**Blacktown Hospital Stage 2 Main Works (SSD 7714)
Notice of Exhibition- Notice of Exhibition**

CD16/10692

Figure 4 Busways 721 map

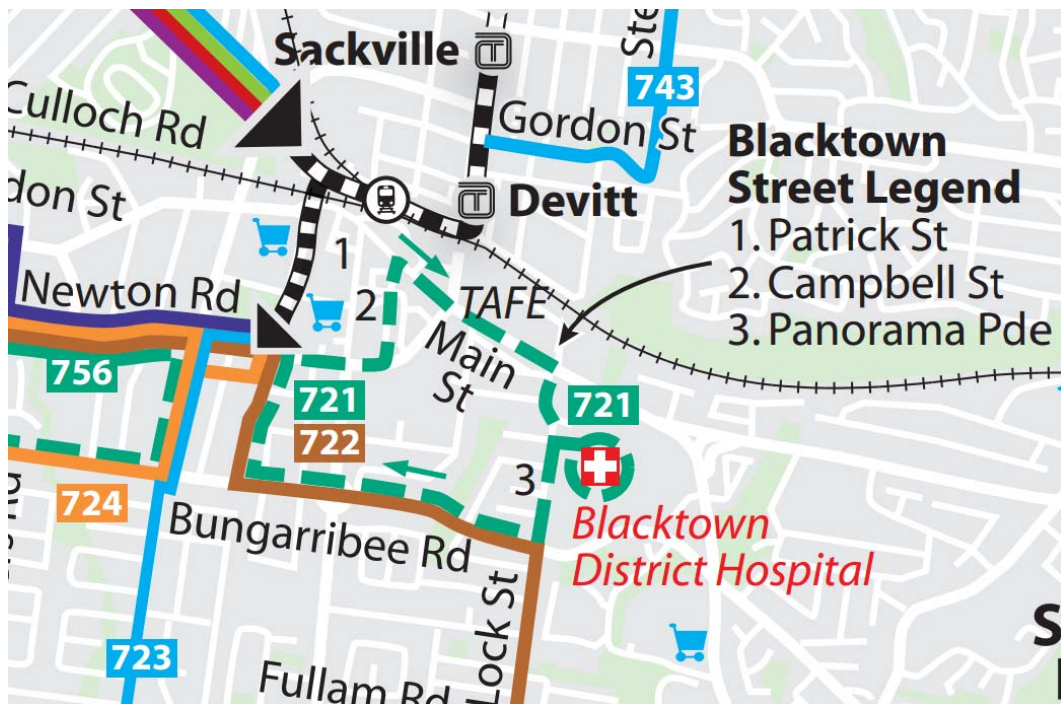
Section 3.6 has an outdated map for route 721 and discusses the incorrect route operations. This is also the case for route 722.

It is requested that Section 3.6 be updated to reflect current bus operations.
